KITTITAS COUNTY
DEPARTMENT OF PUBLIC WORKS

MEMORANDUM

TO: Community Development Services
FROM: Taylor Gustafson, Environmental/Transportation Planner *TG*
DATE: May 4, 2018
SUBJECT: LFP-18-00002 Evergreen Ridge PUD Parcel B Division 2

**EVERGREEN RIDGE P.U.D. - PARCEL B, DIVISION 2**  
**A PORTION OF THE NORTH 1/2 OF SECTION 12,**  
**TOWNSHIP 20 NORTH, RANGE 14 EAST, W.M.**  
**KITTITAS COUNTY, STATE OF WASHINGTON**

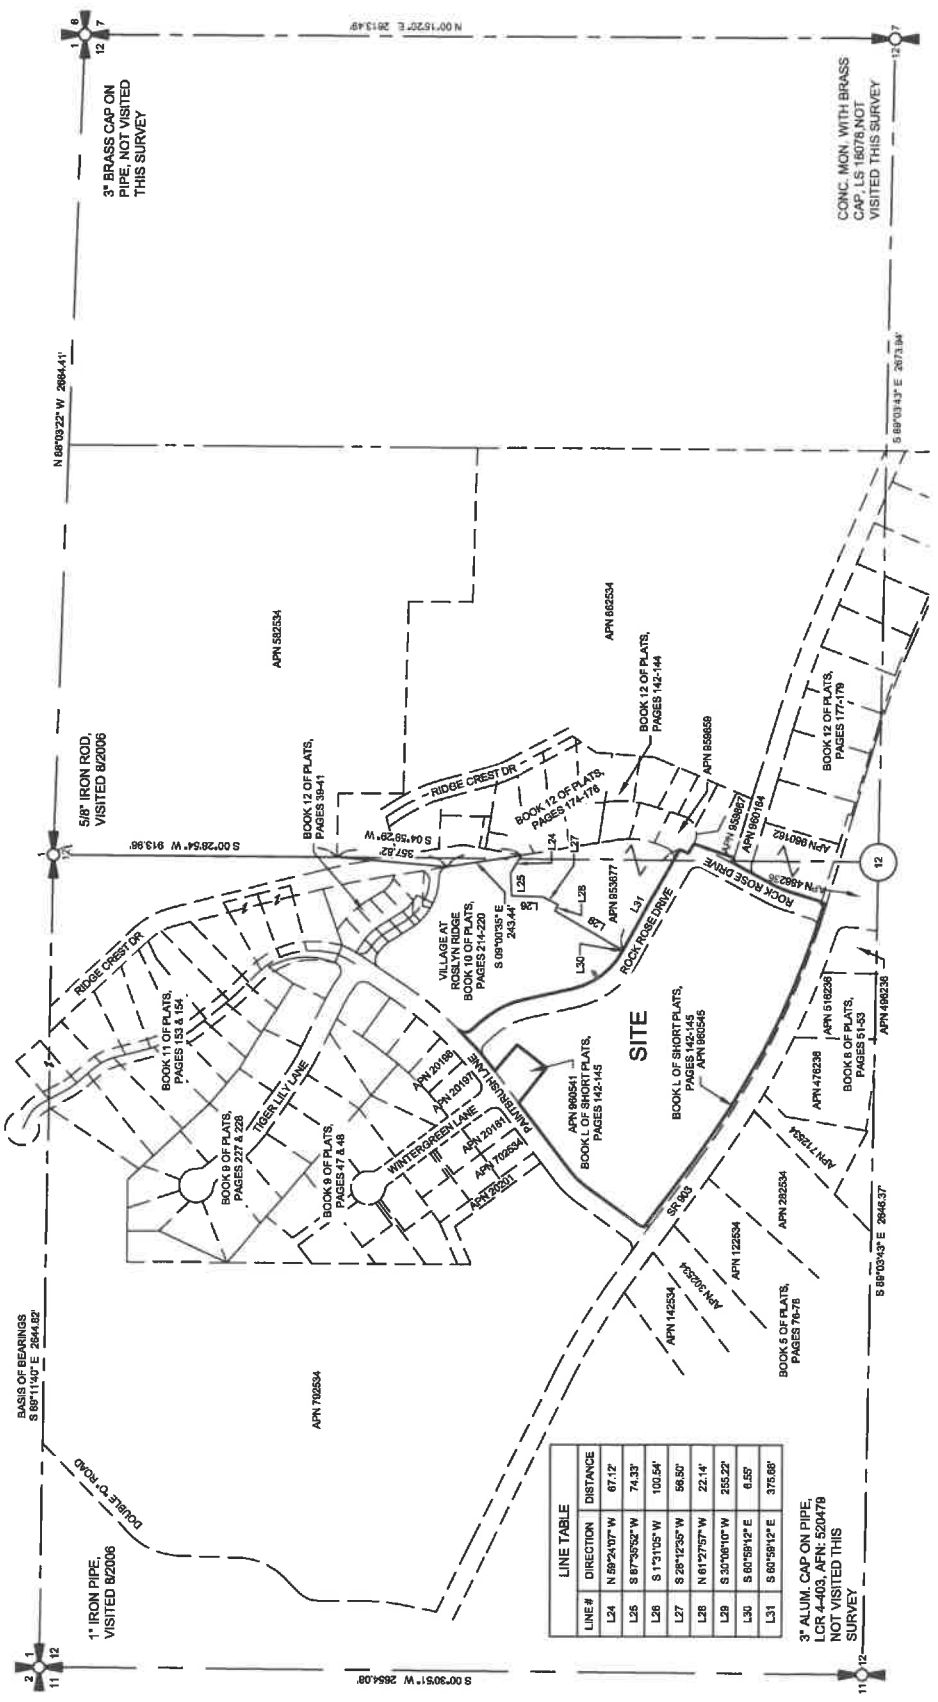
1. Site Plans are stamped "Preliminary". A sealed copy is required for final plat.
